**WELWYN HATFIELD BOROUGH COUNCIL  
EXECUTIVE DIRECTOR - PLANNING, PUBLIC PROTECTION AND GOVERNANCE**

**DELEGATED APPLICATION**

**Application No:** 6/2018/3182/FULL  
**Location:** 12 Harpsfield Broadway Hatfield AL10 9TF  
**Proposal:** Mixed-use development comprising of 8 student residential units (incorporating 21 study bedrooms), 169 sq.m of a4 commercial space(existing) with the associated on-site parking, pedestrian access, refuse and cycle storage  
**Officer:** Mr William Myers

**Recommendation:** Refused

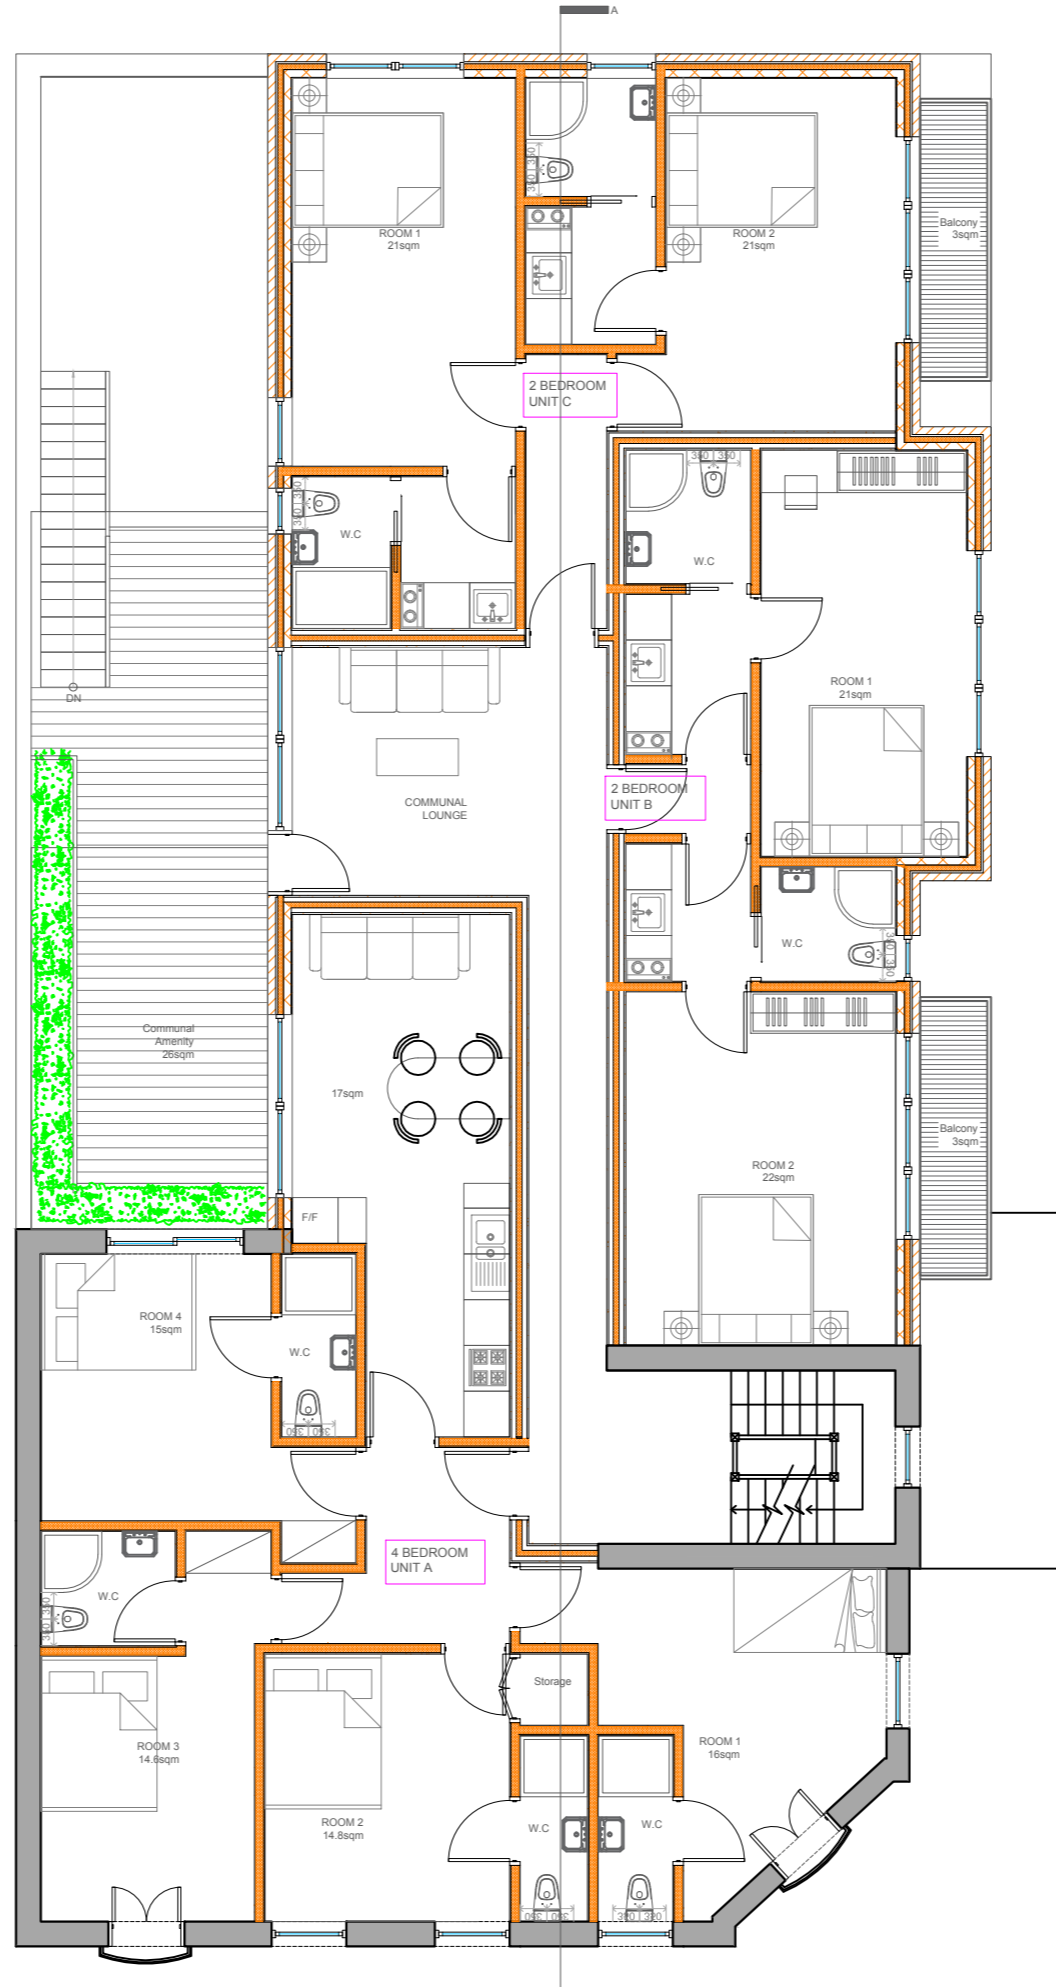
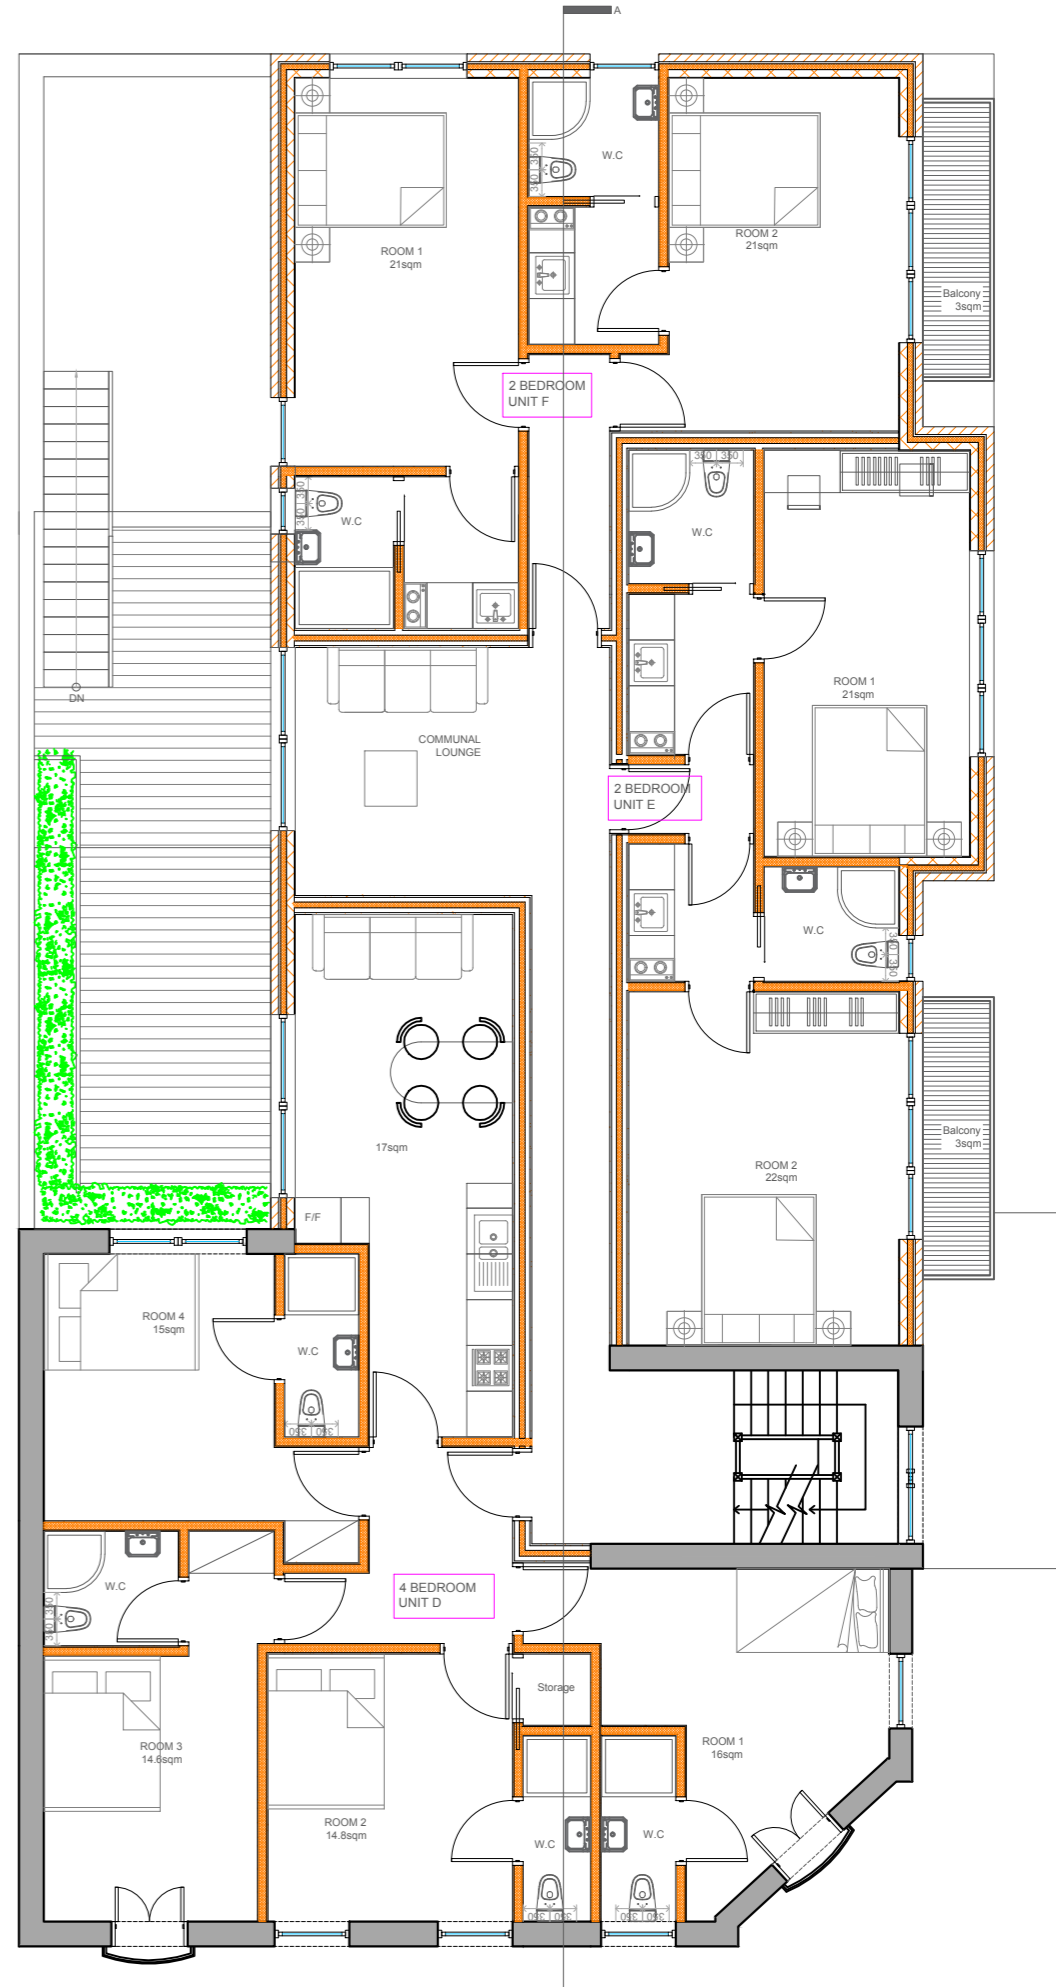
The proposed positioning of the amenity area at first floor level outside the windows for the communal kitchen/dinner and bedroom four of what is referred to by the applicant as Unit A, does not amount to a high quality of design. The reason for this is because this communal space would be directly outside the only window that serves bedroom 4 of Unit A. As this amenity space would be available to up to 21 residents at any time during the day or night this would mean that the occupier of this room would likely be regularly disturbed by other residents using this space for social purposes. In addition, as the staircase that serves this communal area provides an access to the residential part of the building it is judged that it would be common for residents to use this access at any time during the day or night, and at all times of the year. In addition, there appears to be inaccuracies between what is shown on the floor plans and what is shown on the elevation drawings with regards to the vegetation that is shown in front of bedroom four on the floor plans but not on the elevations. Notwithstanding this, the vegetation shown on the floor plan would not be sufficient to protect the amenity of the future occupiers of this room and could have further negative impacts on the quality of accommodation in terms outlook and daylight.

A further inaccuracy within the submitted plans is that the floor plans appear to indicate an access into the bus station area to the rear of the site but the elevations do not show this. It is judged if a door is proposed within this elevation that such an access would be unacceptable because the door would open immediately onto a bus station. As a result such this layout and access arrangement would constitute poor design.

<p><i>Future occupants</i></p> <p>It is considered that the proposed use of obscured glazing within every window that would serve a communal rooms on the first, second and third floor would constitute poor design and it would make these rooms materially deficient for future occupiers. This deficiency would mean that future residents would not be provided with adequate communal space.</p> <p>As the proposed use of the ground floor of the building would be as a bar, and such a use is likely to generate a significant amount of noise, it is judged in accordance with the comments from the Council's Public Health and Protection Team, that a detailed noise assessment of this use would need to be carried out before its acceptability could be appropriately assessed. As it stands insufficient information has been provided by the applicant to demonstrate that future occupants would not be unacceptably impacted by the use of the ground floor of this building as a bar.</p>

Loft Floor Plan-Proposed

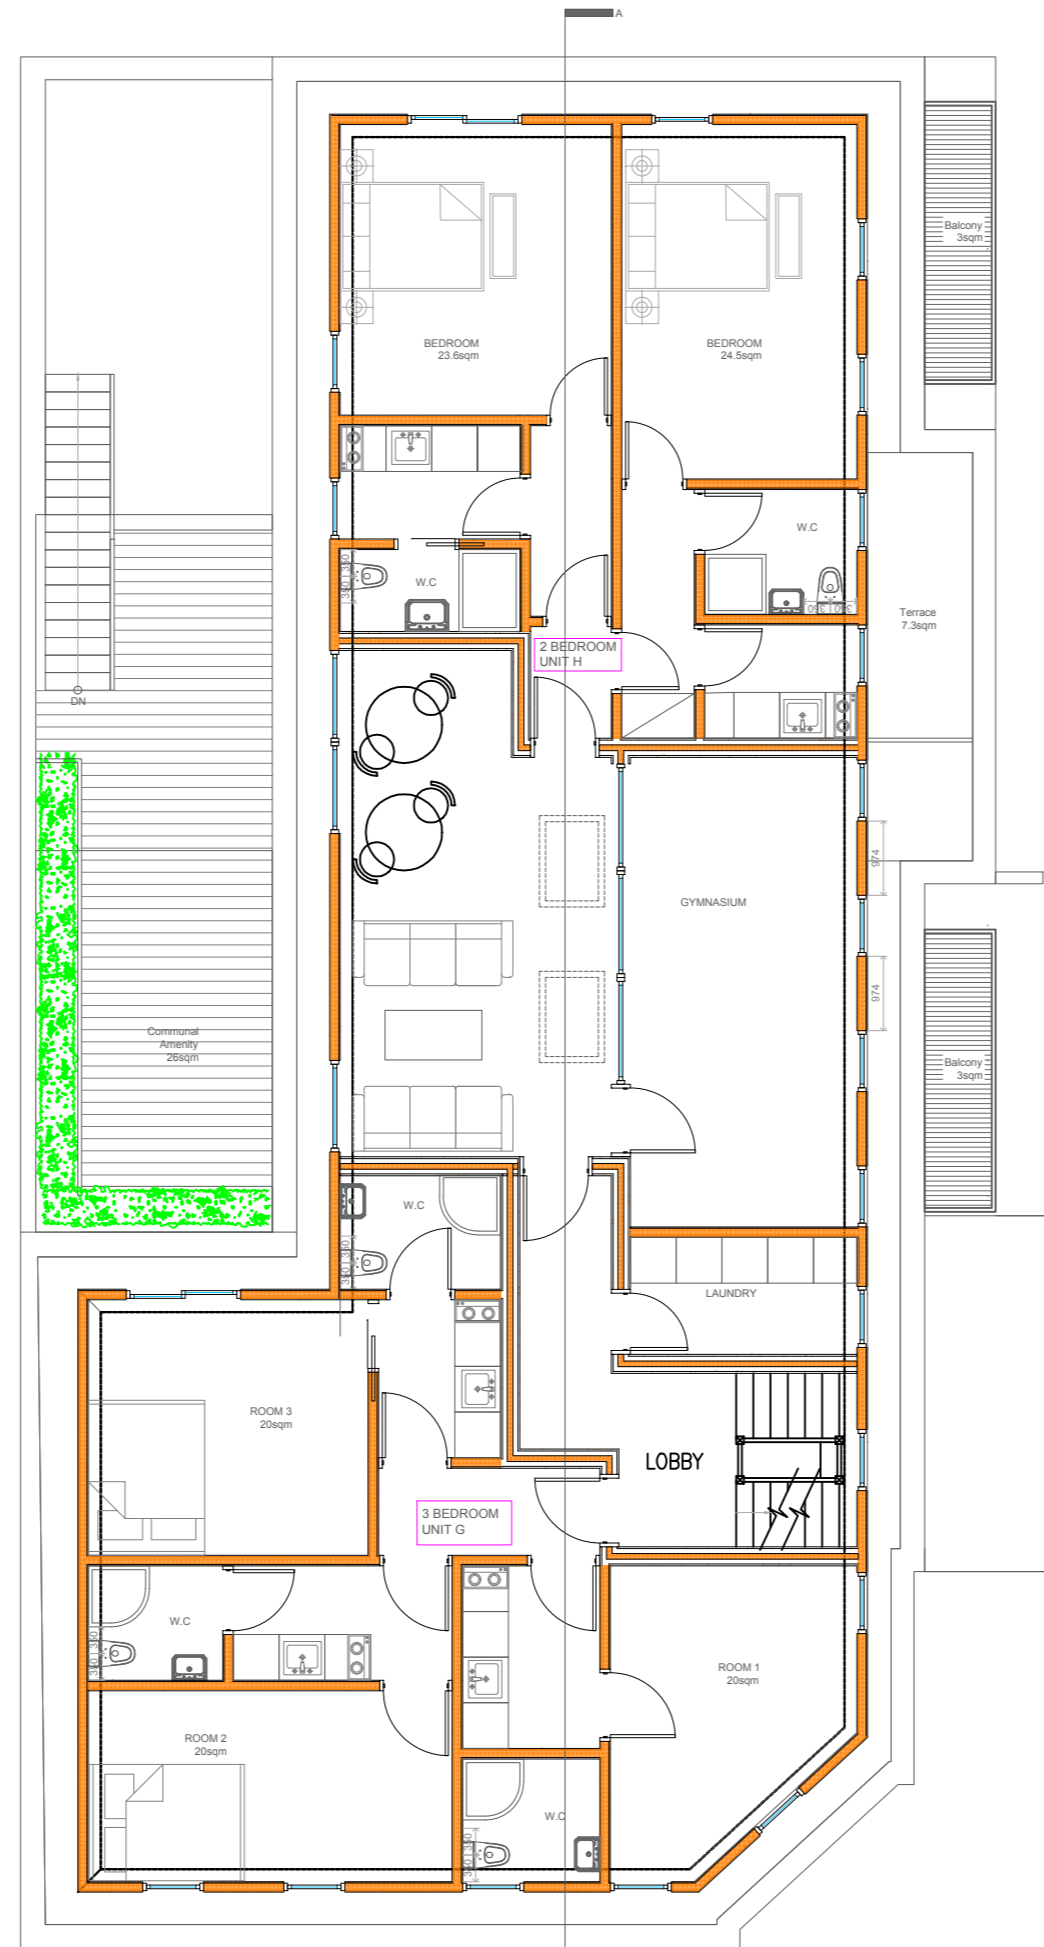
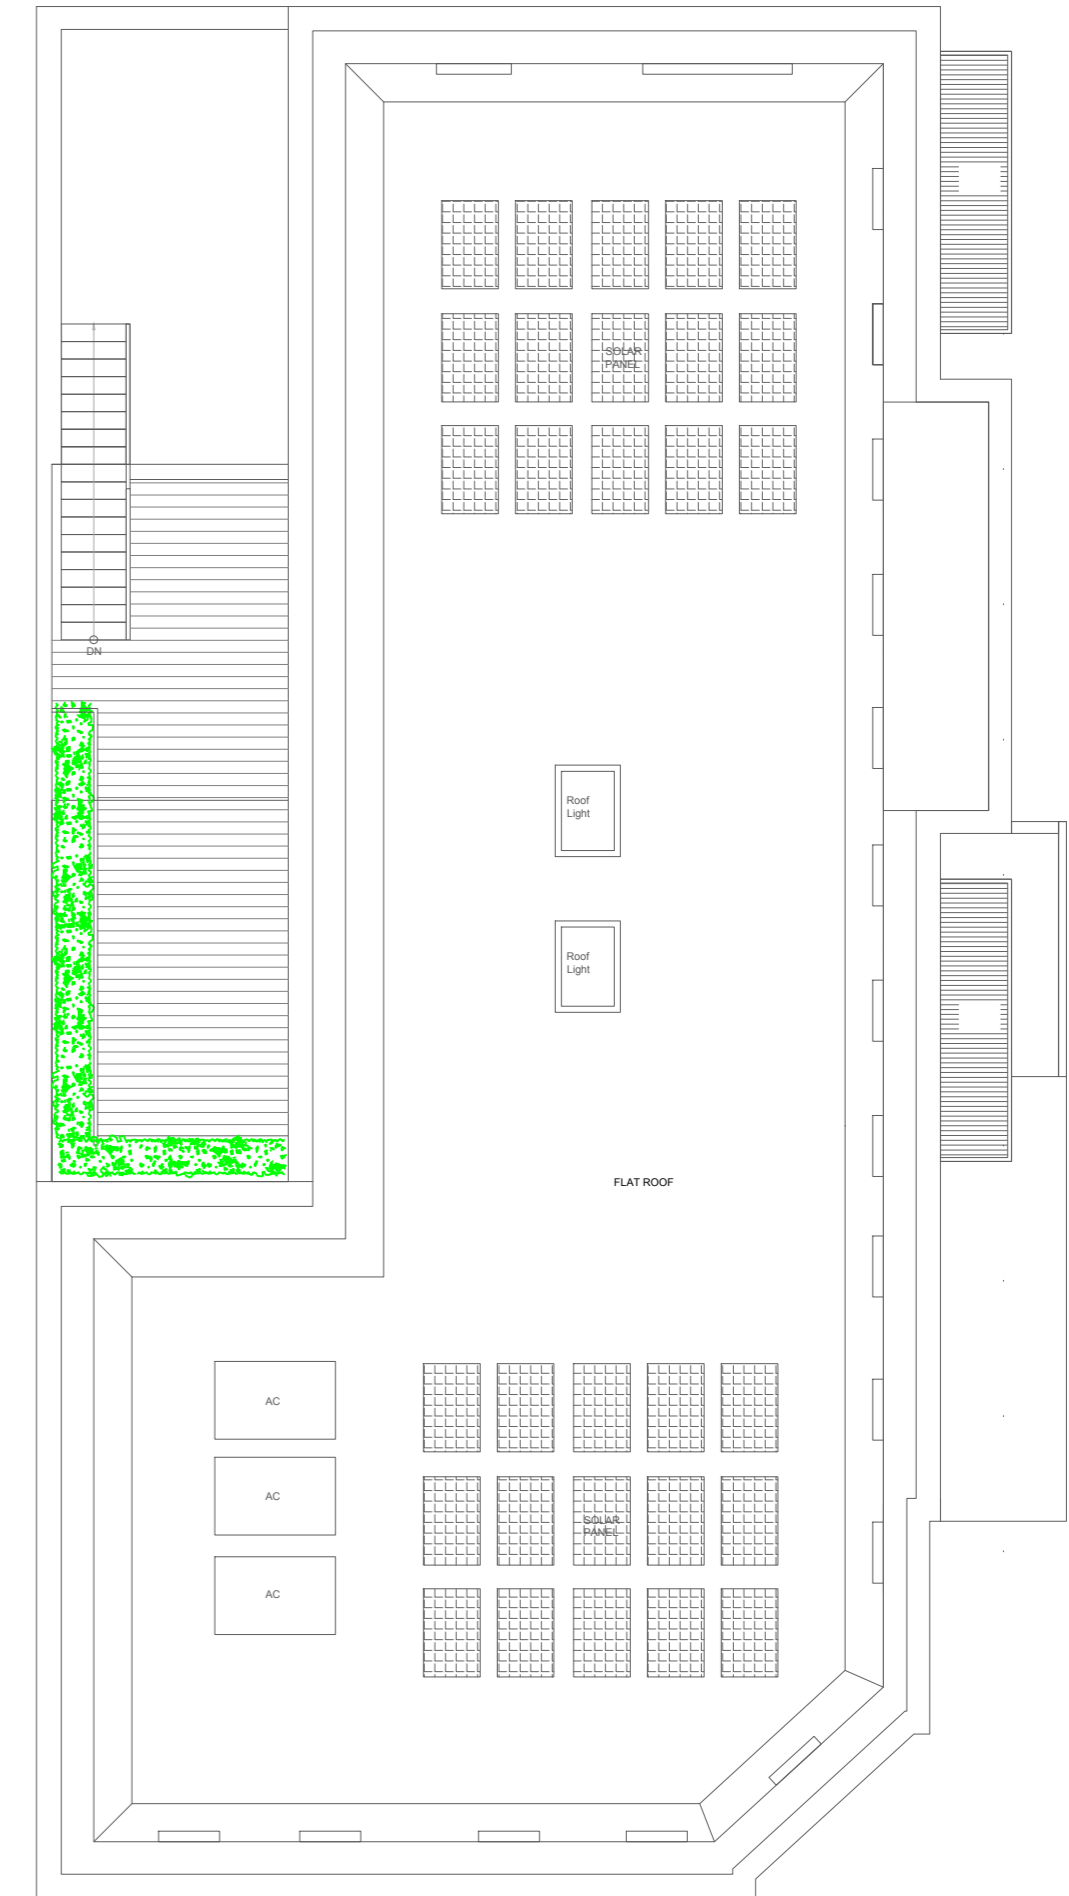
The proposed mansard roof reflects the adjoining terrace and is sympathetic in scale to its environment and to the original property. The roof extension would project approximately 1.8m above the existing parapet and would be set back approximately 600mm from the outside wall of the building on all sides. It is relevant that the visible bulk from public vantage points at ground level would be limited due to the height of the building and the set back.
